RE: MICA SEPA Checklist Comments

Thank you for the opportunity to comment on the SEPA Checklist and associated environmental documents, along with the proposed zoning code amendment for MICA's proposed performance arts theatre. Based on Concerned Citizens for Mercer Island Parks' (CCMIP) review of these documents, we request that the City withdraw the Determination of Non-significance (DNS) for the following reasons:

MERCER ISLAND CENTER FOR THE ARTS CONCEPTUAL MITIGATION PLAN

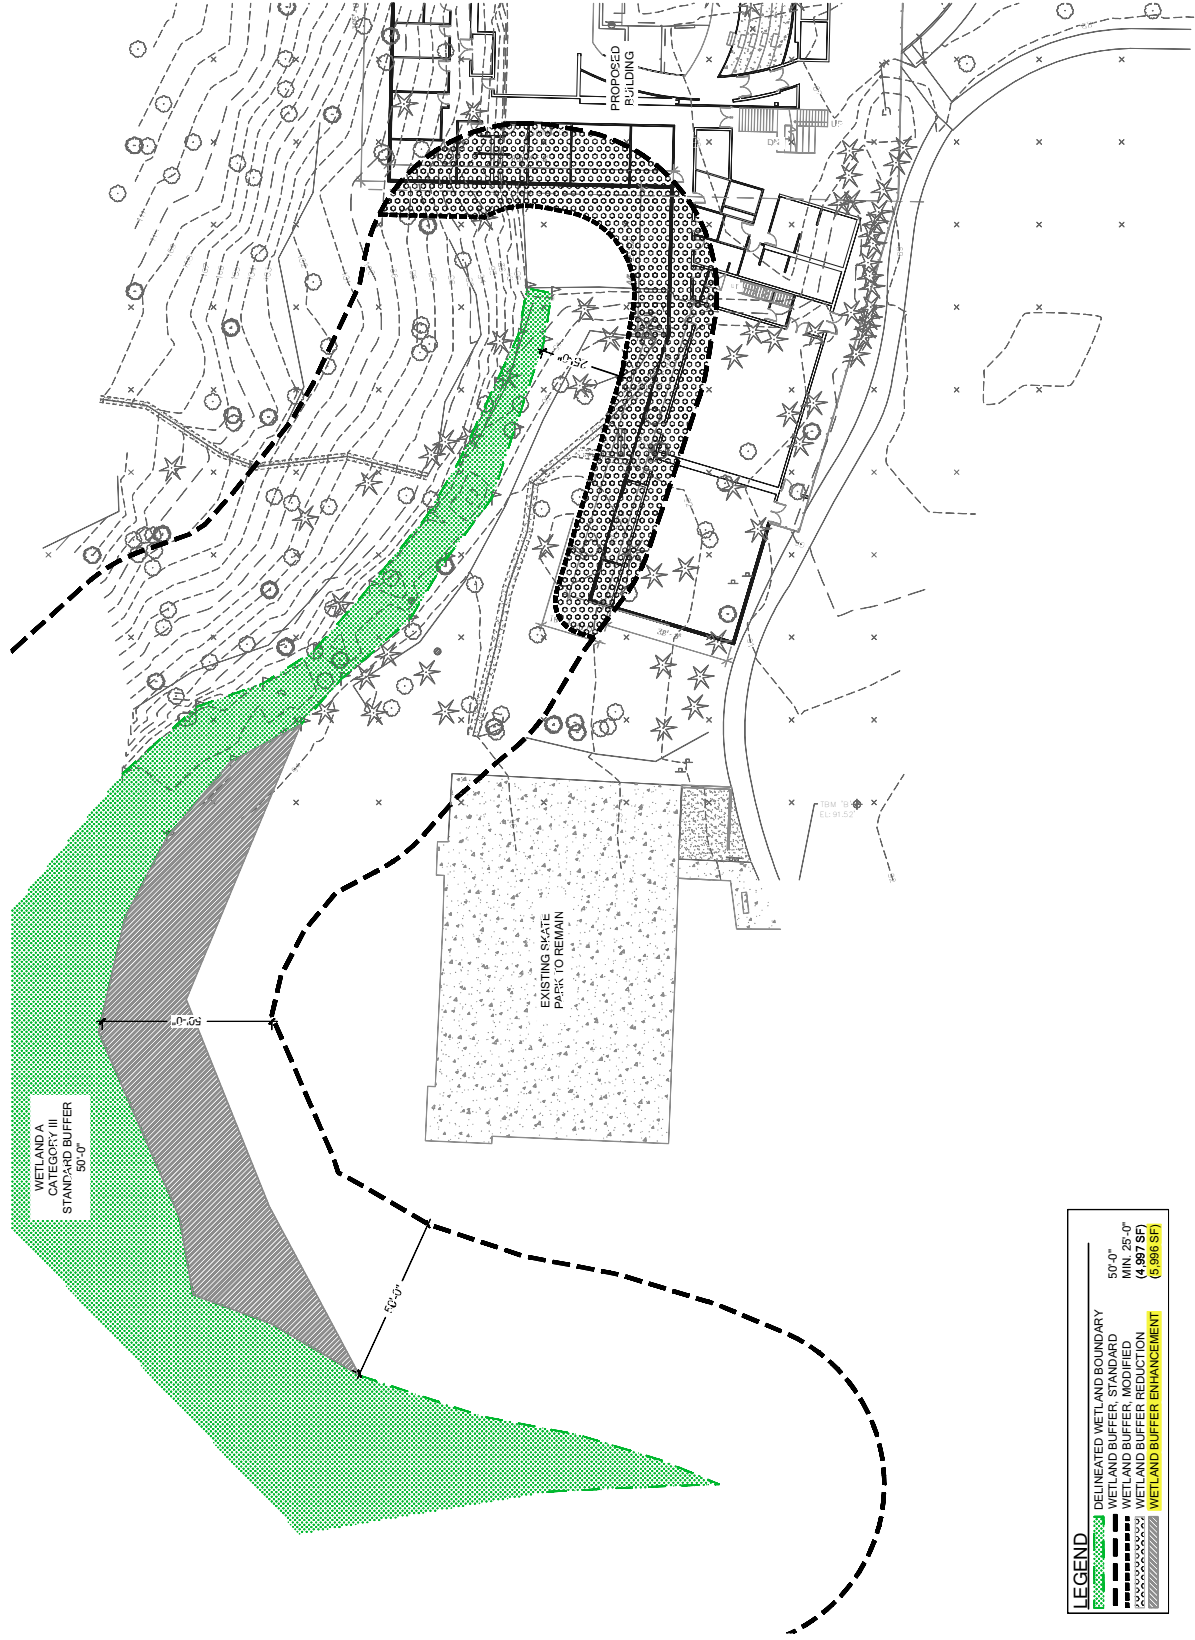
7. Section B(3)(d) requires “Proposed measures to reduce or control surface ground and runoff water impacts, if any:” MICA’s response to this issue is that “Surface runoff from the hillside will be intercepted by the proposed swale that will be strategically graded into the hillside to minimize impacts to the existing vegetation. Wetland mitigation for buffer reduction is addressed in Attachment F: Mercer Island Center for the Arts Conceptual Mitigation Plan, prepared by the WC. Water from impervious surfaces will be handled per item C.1. above.” We find Attachment F unclear in clarifying how wetland mitigation for buffer reduction is addressed. It seems to indicate that there will be 3,000 square feet of wetland creation and 10,458 sq. ft. of buffer restoration. If this is true then it appears that the footprint for the MICA area is being expanded by at least 25% and if so, it has reduced the amount of parkland while at the same time expanding the amount of land needed for MICA.

10. Section B(8) asks for information regarding land use. The proposed lease boundary fails to acknowledge that the actual land disturbed is larger than proposed. The project will disturb an existing Mercedale hillside as mitigation site. Also, the design for the detention vault and associated pipes will require additional land area that is outside the current lease line. Please add a drawing that identifies the temporary construction easements. And, who will maintain the detention pond?

## Appendix E: On-Street Parking Utilization Study

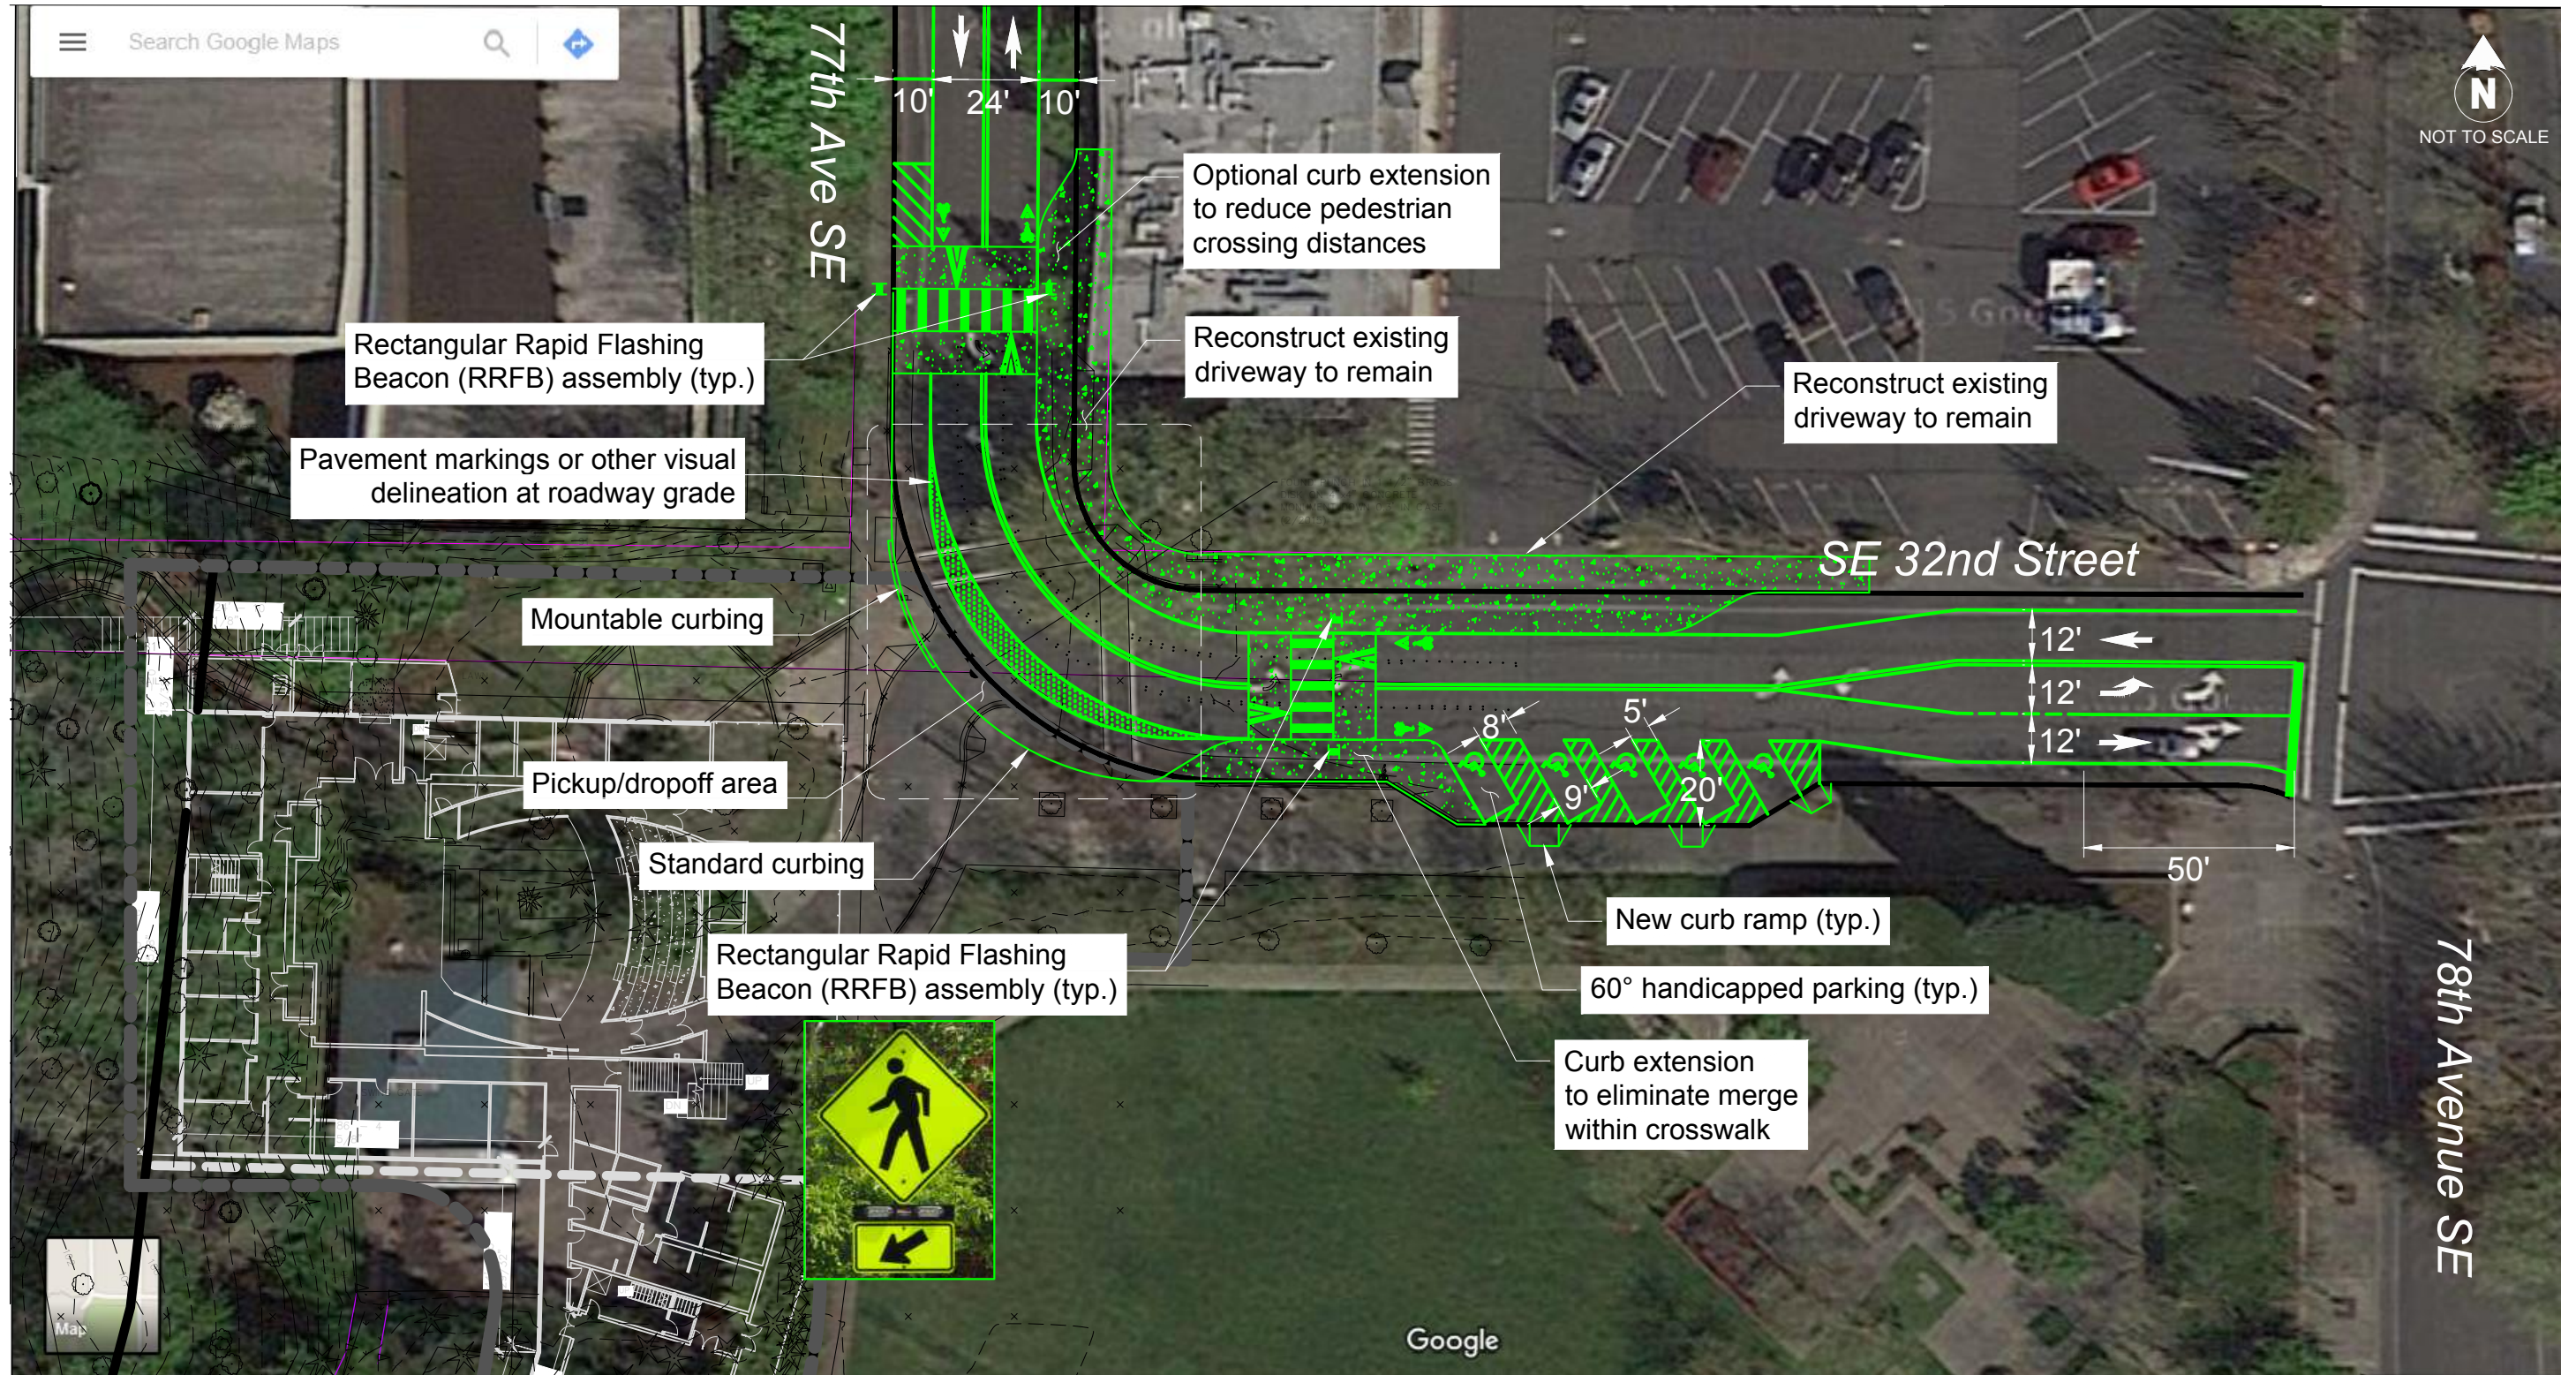
We have additional serious concerns and questions about the methodology used about the on-street parking evaluation. What two days was on street parking study done? MIHS was on spring break week of April 11-15. A new grocery store, New Seasons, is opening very soon near streets surveyed. Its presence is likely to consume parking. Commuter (including RPZ) parking continues to consume on-street space supply as MI park and ride lot demand is over capacity. On street parking should not be assumed as part of the MICCA parking supply.

# 77th Avenue SE On-Street Parking Concept

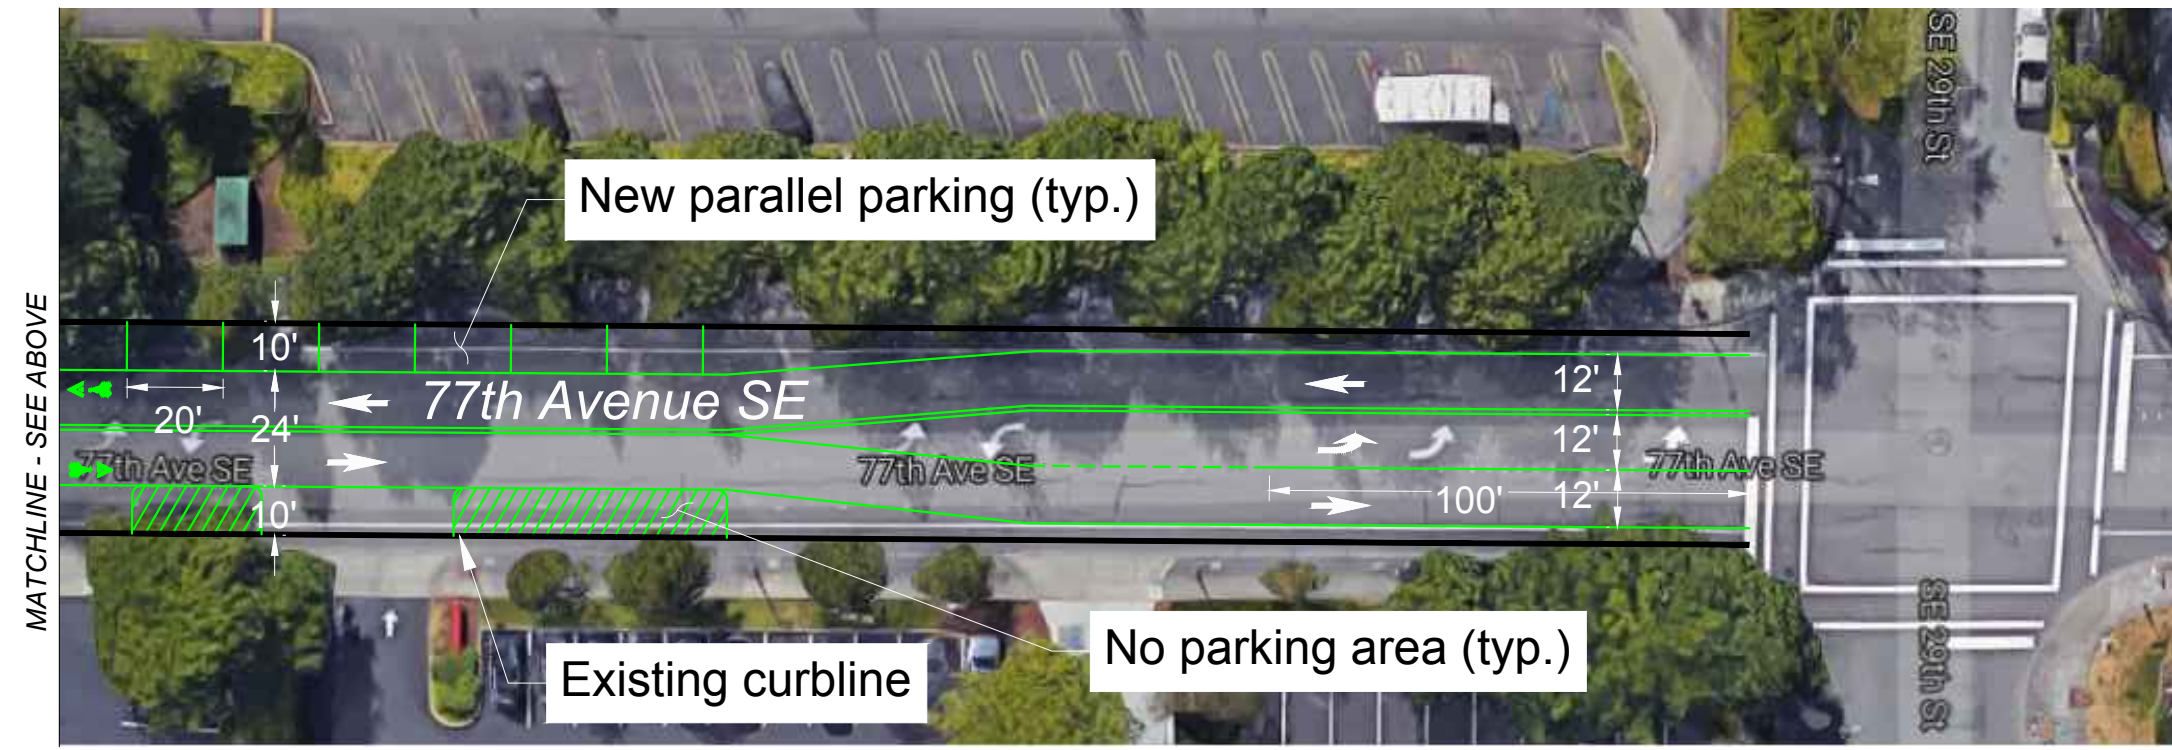
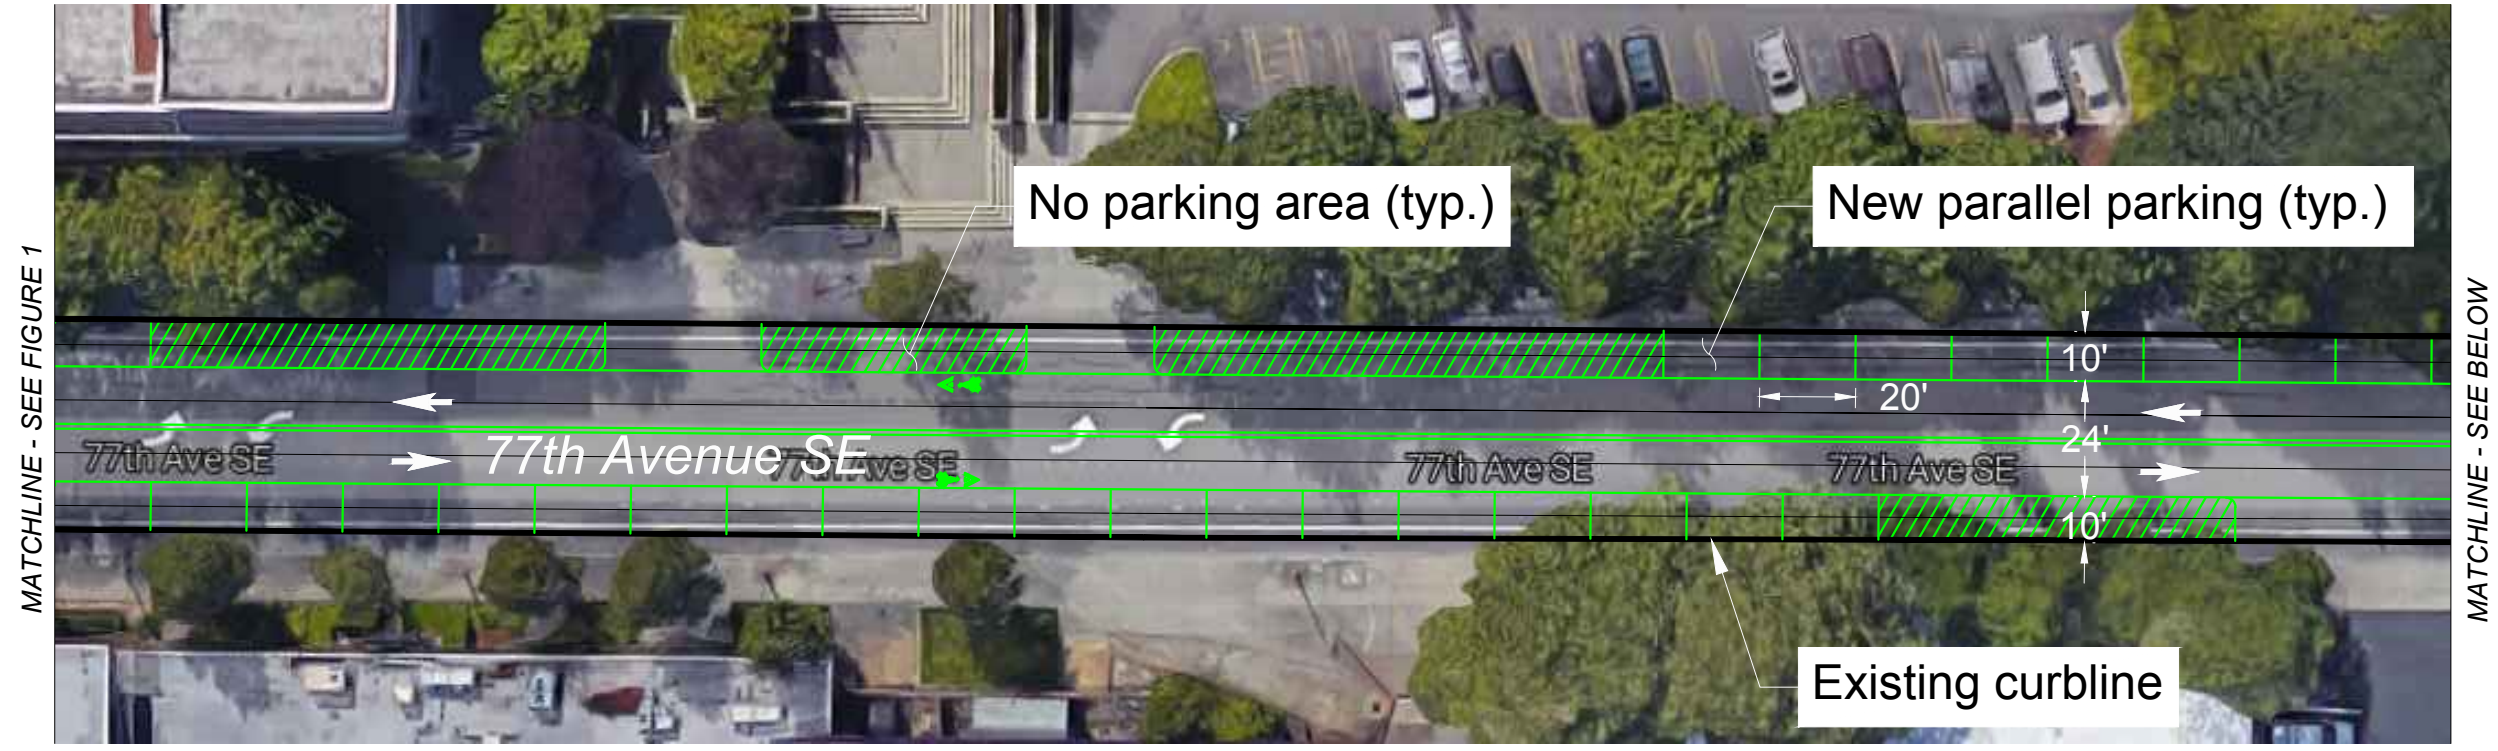
15. Section B(14)(c) asks “How many parking spaces would the completed project have? How many would the project eliminate. MICA’s response is that “The project will not eliminate parking. Parking will be available on nearby streets and through arrangements with MICA and nearby private owners.” MICA provides no evidence that it has engaged with nearby private owners. Through independent consultation it was determined that Farmers Insurance was not notified of the plan and had no knowledge of the propose parking plan. It is questionable that private property owners would agree with the proposed text code amendments that impose conditions that are arbitrary, capricious, and onerous. Given that it’s likely no off-street parking would be available, and even with the proposed restriping of 77<sup>th</sup> street it appears that this is a show-stopper.
